Consultation Response from KC Landscape

Application No:	2024/92281
Proposed Development:	Erection of 23 dwellings
Location:	Land adj, 17, Whitehall Road West, Birkenshaw, BD11 2LS
Applicant/Agent:	Orion Homes Ltd
Planning Officer	William Simcock
Date Responded:	19.11.2024
Responding Officer:	Em
Responding Ref:	NN53

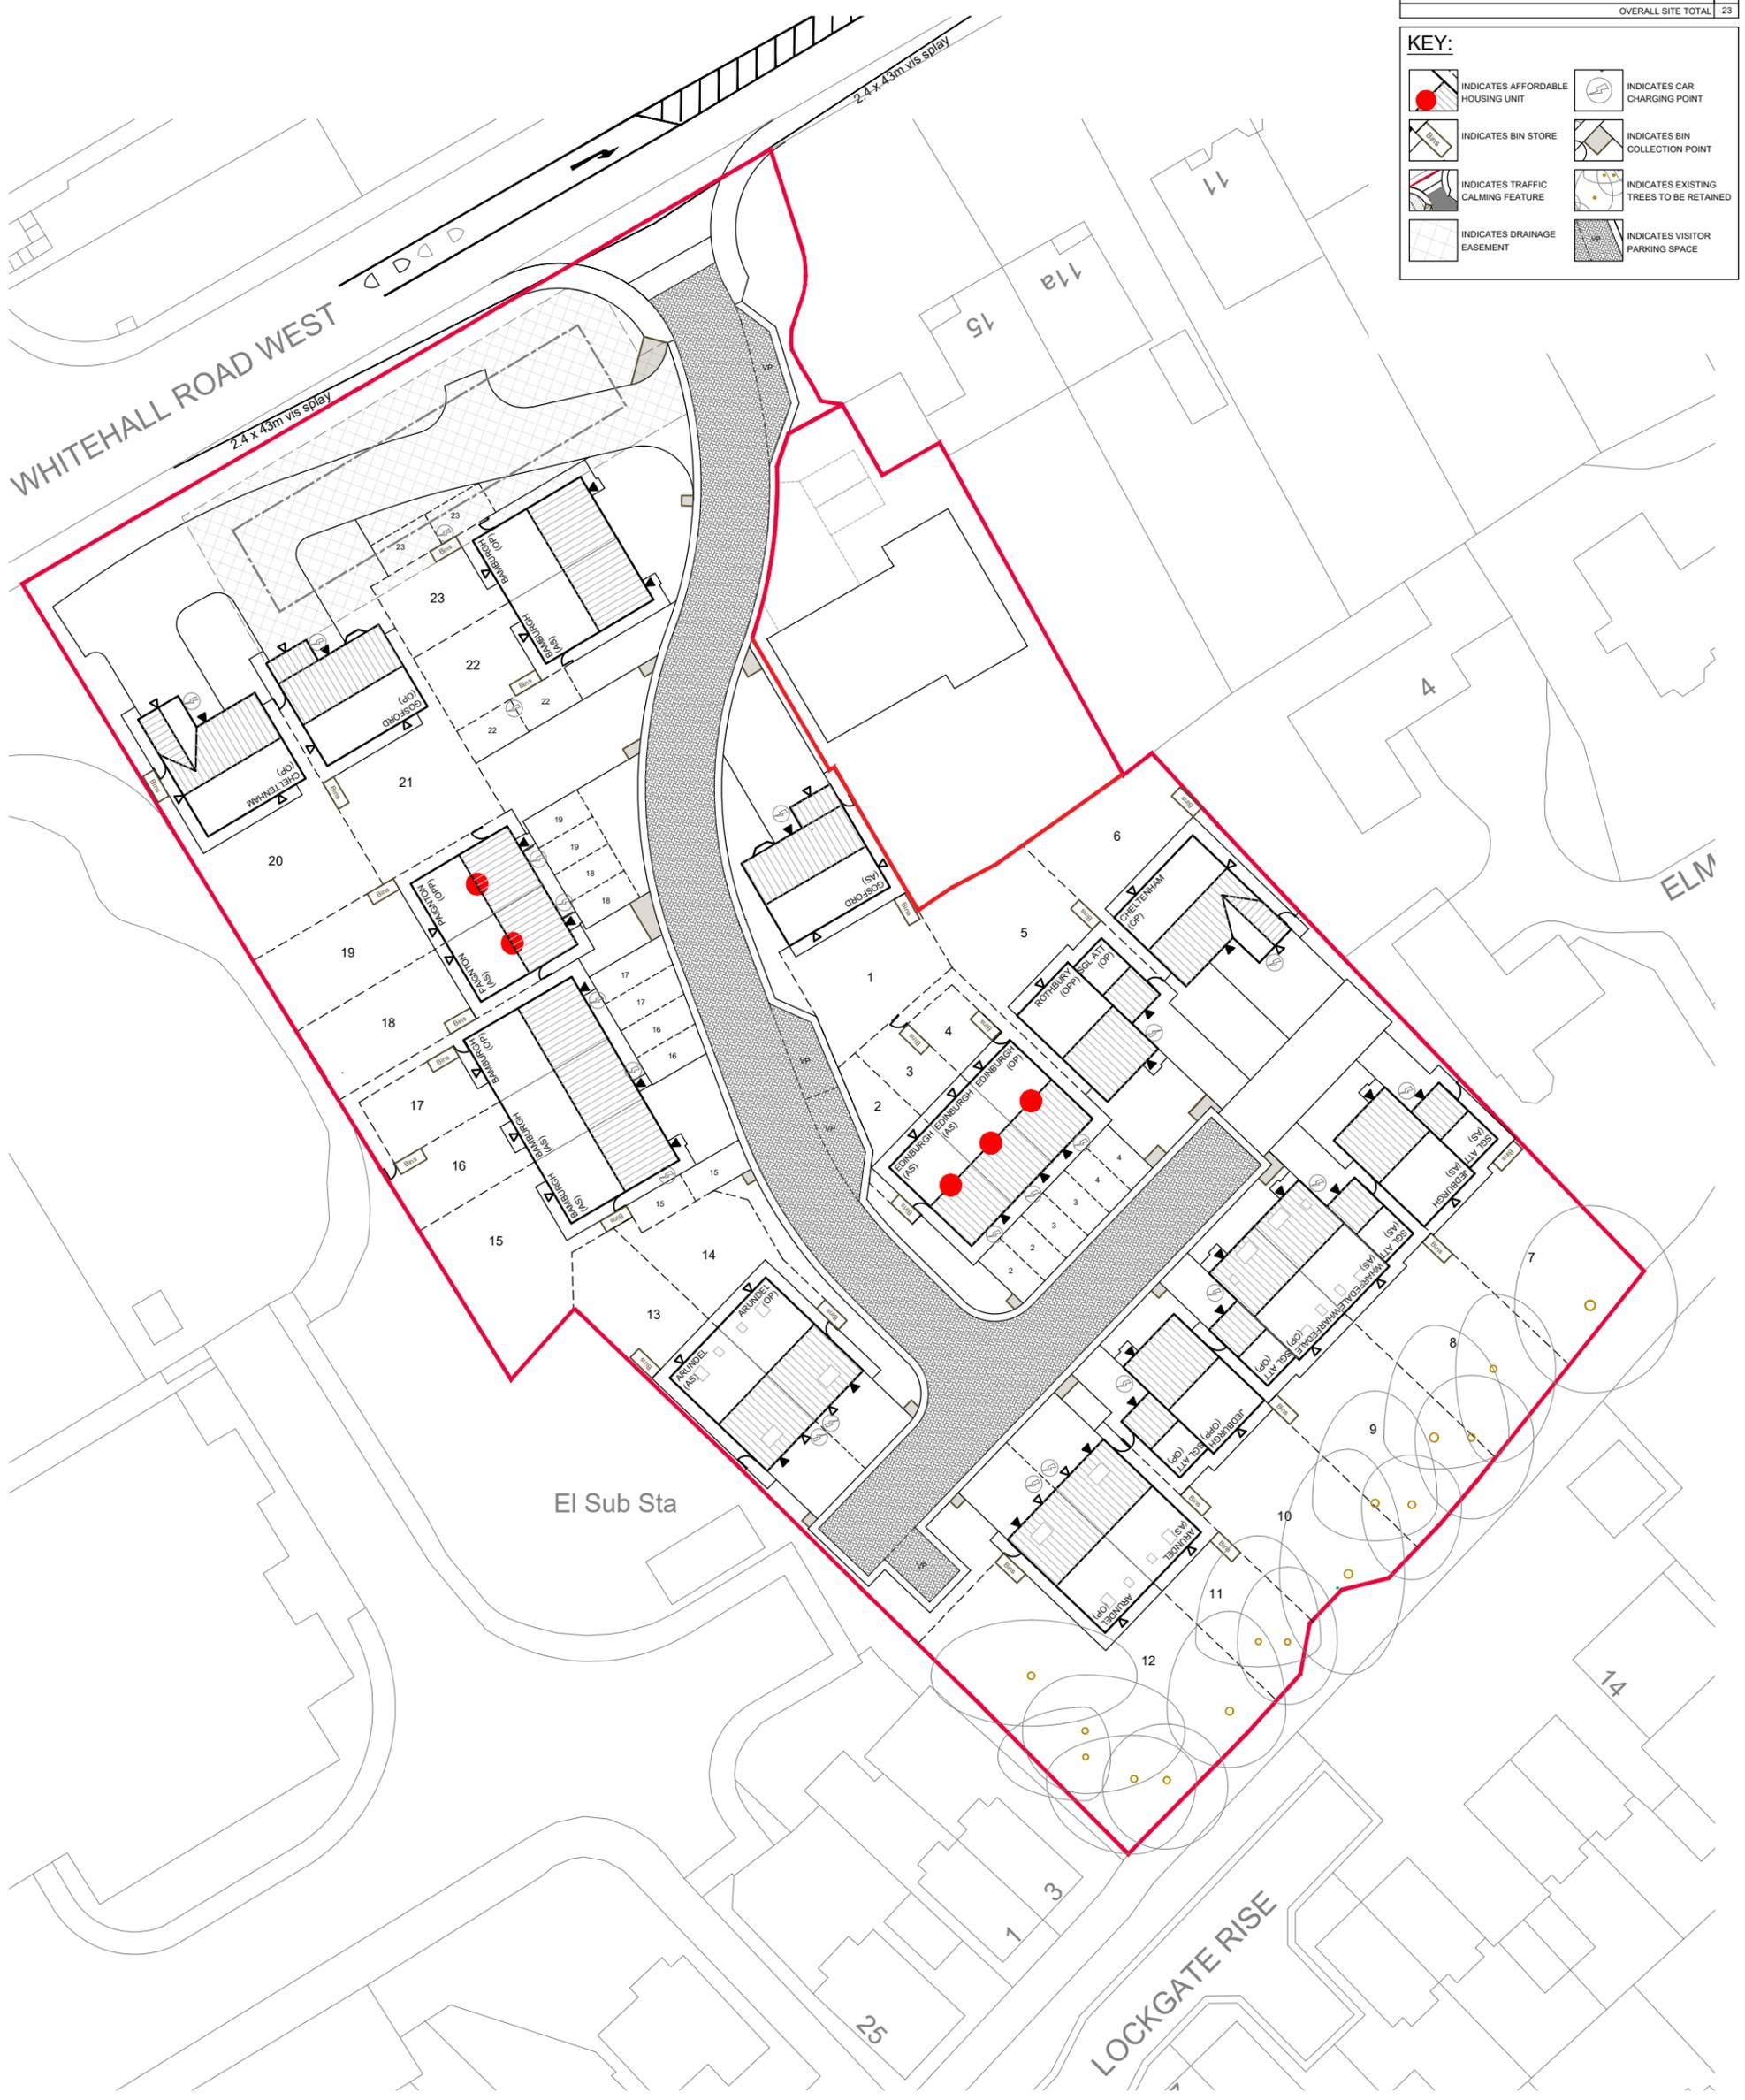
25. **There is no public open space shown on site,**

38. How is the new estate road layout connecting with the surrounding community? unfortunately, it doesn't connect to the PROW to the southern boundary?

35. If the applicant submits a plan showing suitable and appropriate on site open space this would be welcomed and the measured areas of their typologies, we can then re-calculate this sum to reflect the on site provision.

Drawing No H2 240701 1	Drawn by BP	Date 12 Aug 24	Project Whitehall Road West, Birkenshaw
Revision A	Checked by SH	Scale 1:250 @ A0	Client Orion Homes

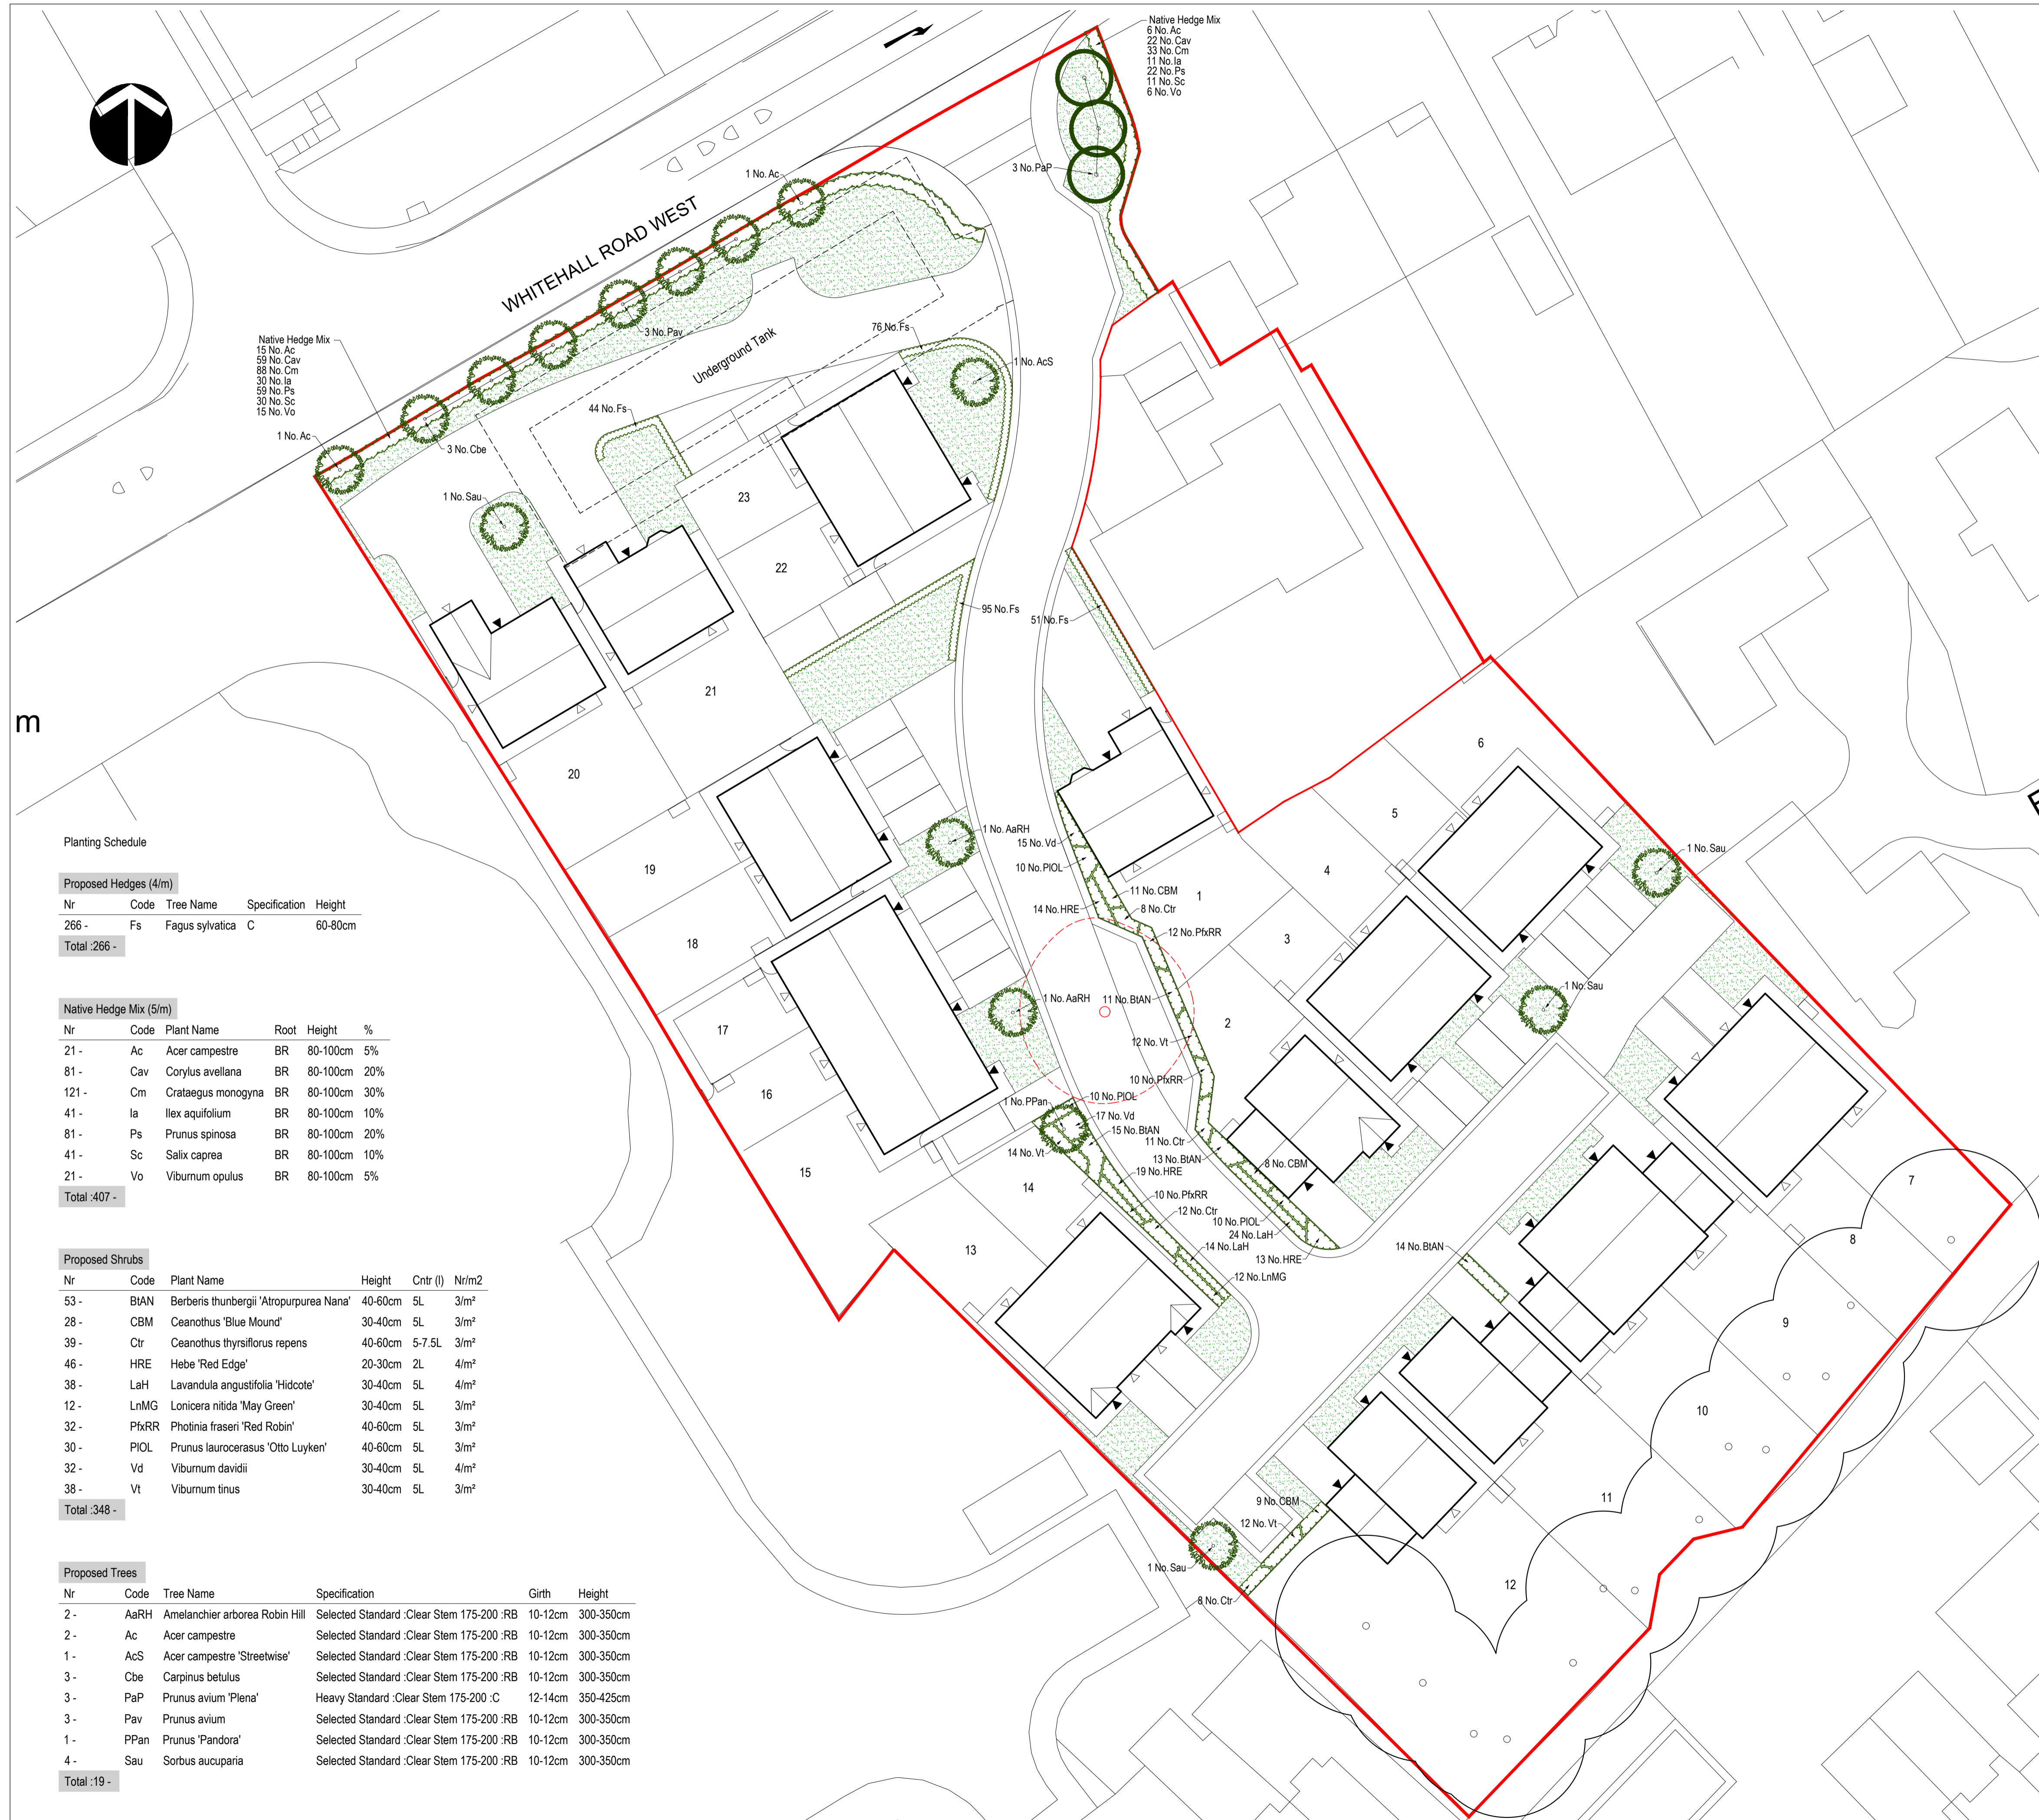
4. The tokenistic trees indicated on the plan are inadequate.
5. Carefully consider all opportunities for appropriate tree planting and other screening planting could additionally help the proposed development comply with policies and guidance regarding design, biodiversity, health and wellbeing and other relevant planning considerations.

6. The scheme as a whole is lacking in proposed landscape planting, an attractive planting scheme to the entrance and enhancement for the Whitehall Road west to the northern boundary. It also does not provide sufficient street tree planting for the development which is a requirement. Trees in rear or private gardens cannot provide the same public amenity and tend to be removed before they reach a size that allows them to contribute to the setting of the development, however, there doesn't appear to be tree planting in rear gardens even.

9. Plans should clearly show the impact of the proposed landscape planting on drainage infrastructure and landscape proposals, particularly frontline tree planting and planting should identify all proposed root protection/barriers, drainage, suds and attenuation or soakaways and all easements to ensure trees are accommodated satisfactorily.

10. Additionally, we would anticipate all new tree planting within 5m of the adoptable highway to include adequate root barrier, clearly identified on the proposed landscape plans.

17. There are more opportunities for strengthening the landscape edge and avoiding dominance of hard surfaces/car parking to frontages.
18. **It doesn't look like any Landscape maintenance and management plan** for the scheme has been submitted. The plans should provide details of planting and maintenance requirements for the trees and planting to meet our expectations.

36. Wildlife and habitat networks, TPO's, PROW : links & connectivity: linkages through green infrastructure are welcomed, however there is little planting to create and link any green corridors to the existing tree belt to the southern boundary along the PROW.

- Please show drainage infrastructure on the landscaping plans, to demonstrate no conflict between trees and drainage.
- pre-commencement condition is necessary to ensure all details relevant to landscape matters and s106 triggers and requirements for POS contributions are agreed at an appropriate stage of the planning process.

Landscape – it would be prudent, given the setting of this scheme, to secure early submission of additional tree planting and landscape frontage/entrance planting details, together with a **Landscape Maintenance and Management Plan and conditions suggested C and D below.**
